Stockland Trust

22nd July 2015

Summary of Response to Council Queries
Yennora Distribution Park

TITLE  
**ESSENTIAL STORMWATER  
WORKS TO DEVELOP  
BUILDING 9**

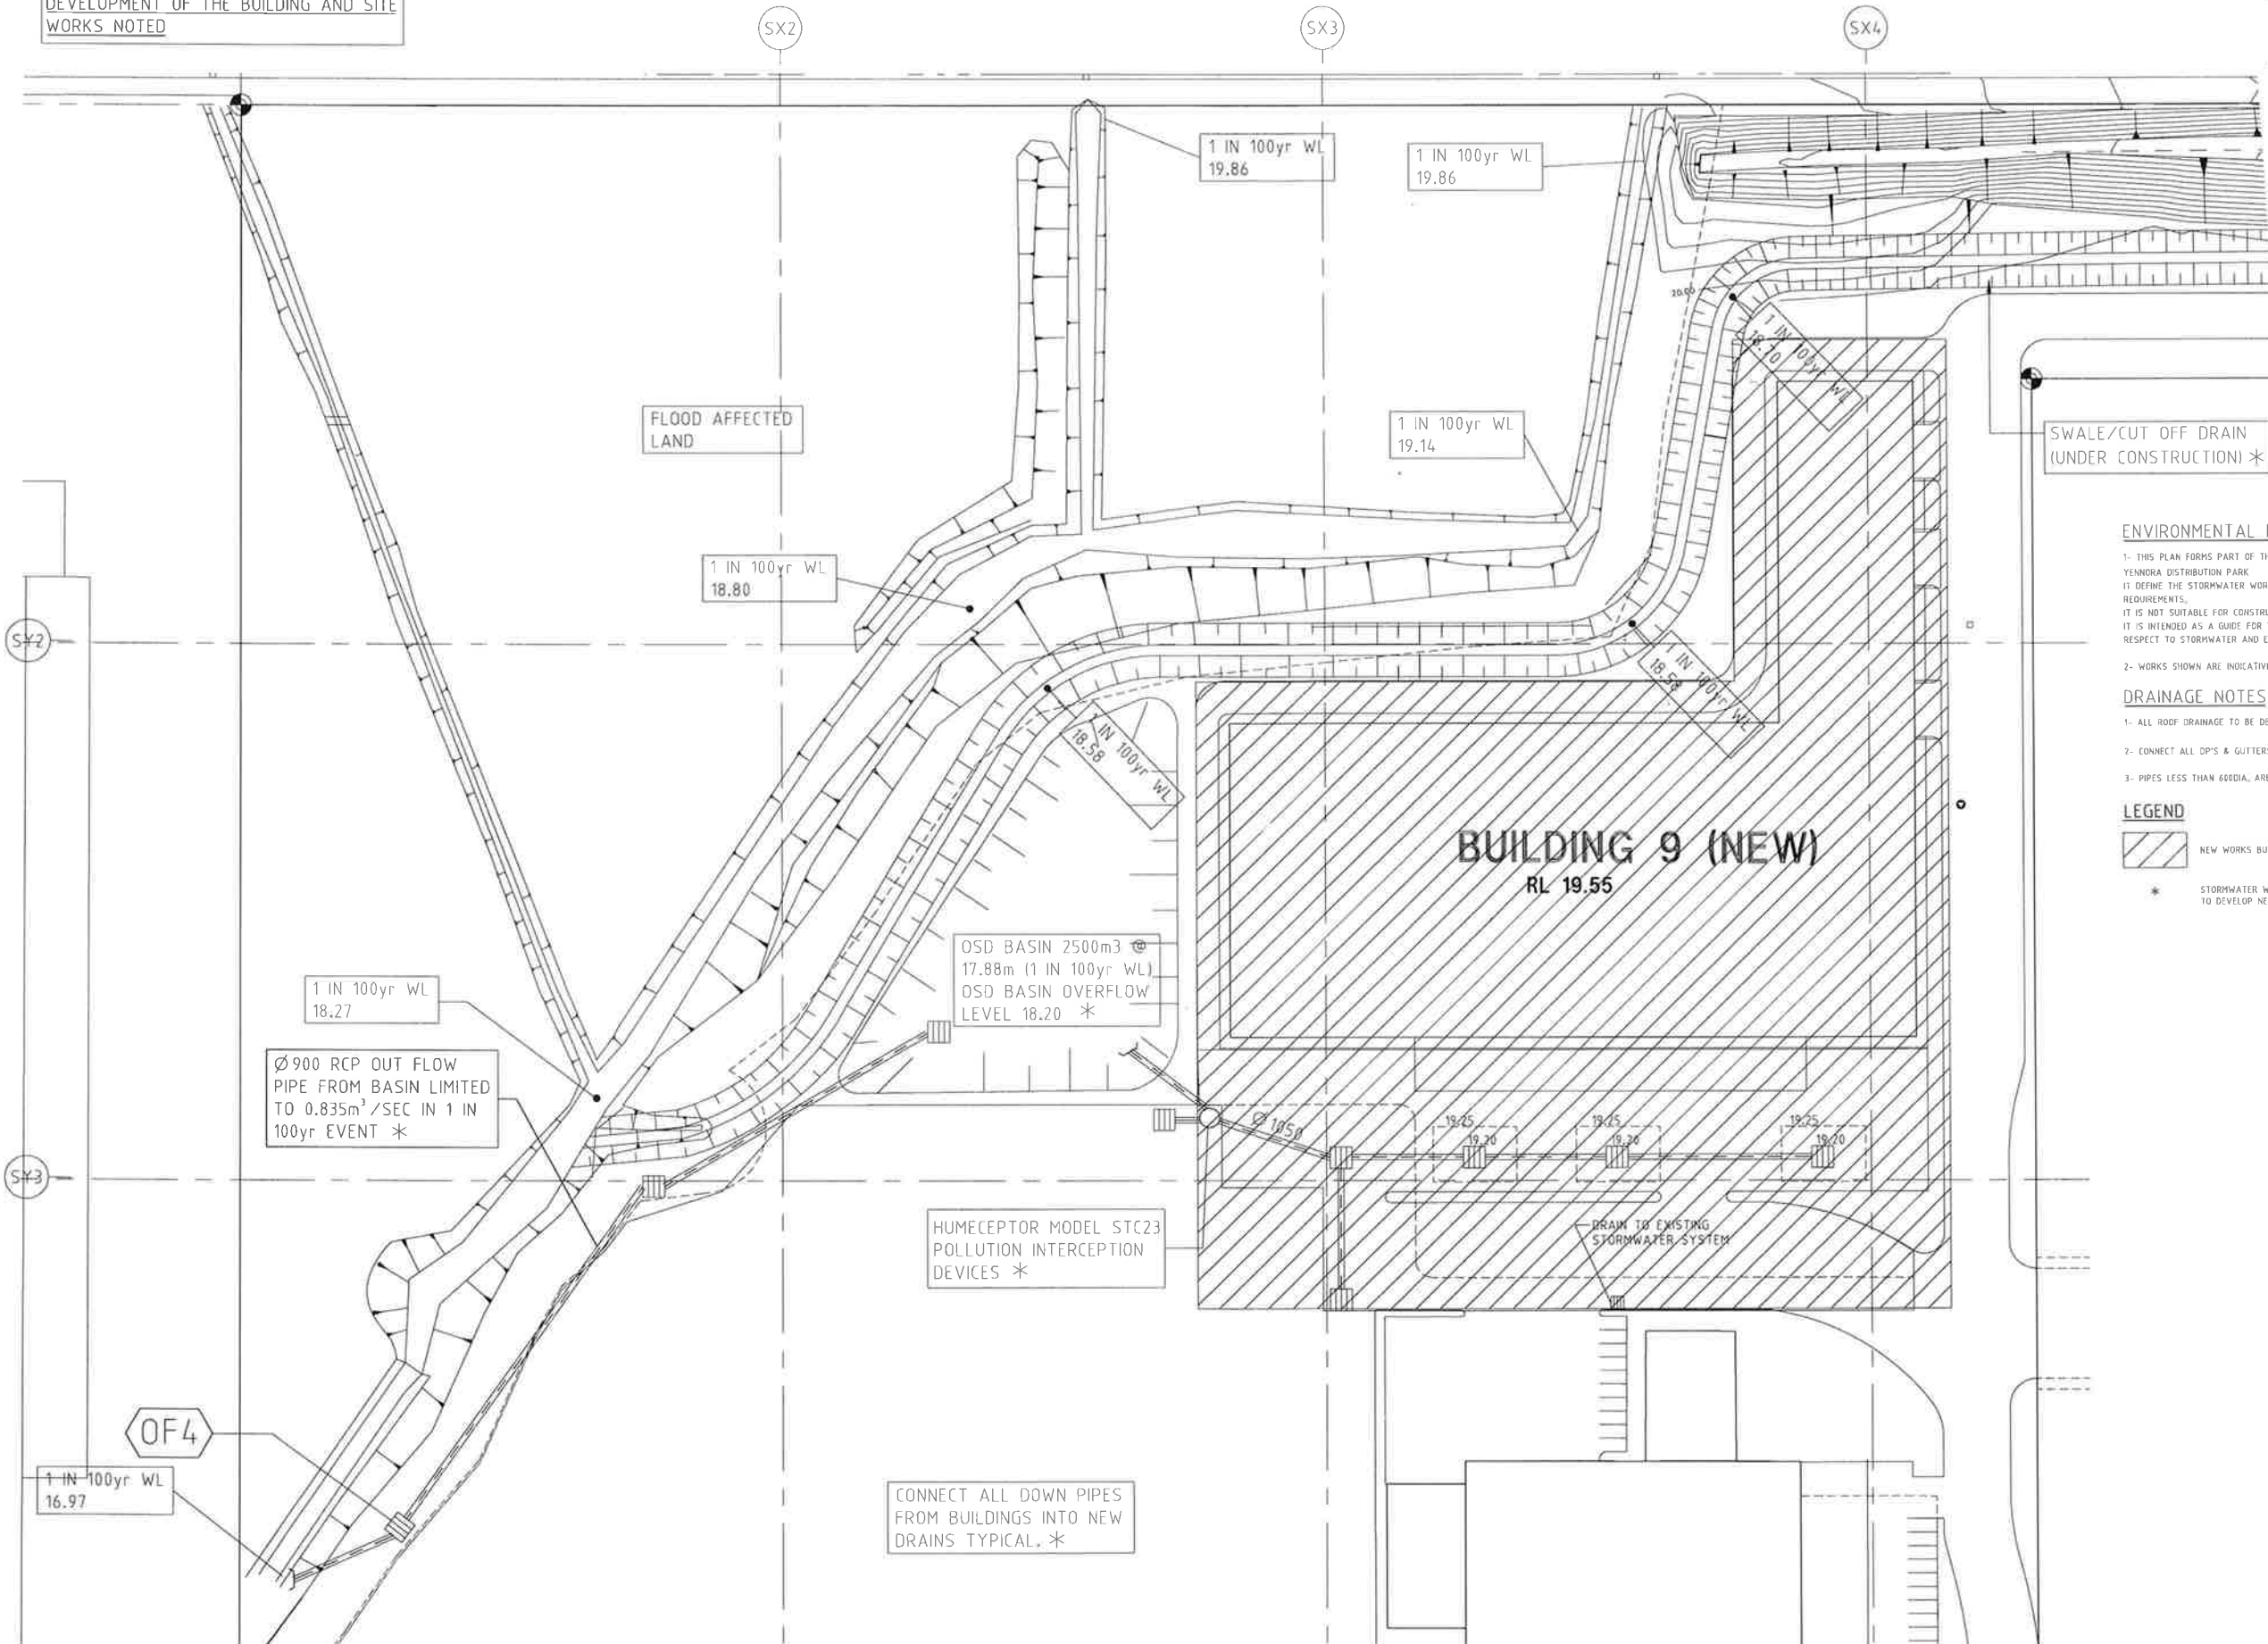
9.A.iv	Based on previous flood assessments the 1% AEP water level in the adjacent drainage paths is 18.70m AHD in the swale in the existing creek (photo3/4) level is 19.14m AHD, with no potential to flow into the development area due to existing mounds and walls. A floor level of 19.50m AHD was adopted for development in this area which is greater than 500mm above 18.70m AHD.	Refer drawing 020083-SMP02 rev A
9A.v	No changes are proposed to fences in overland flow areas
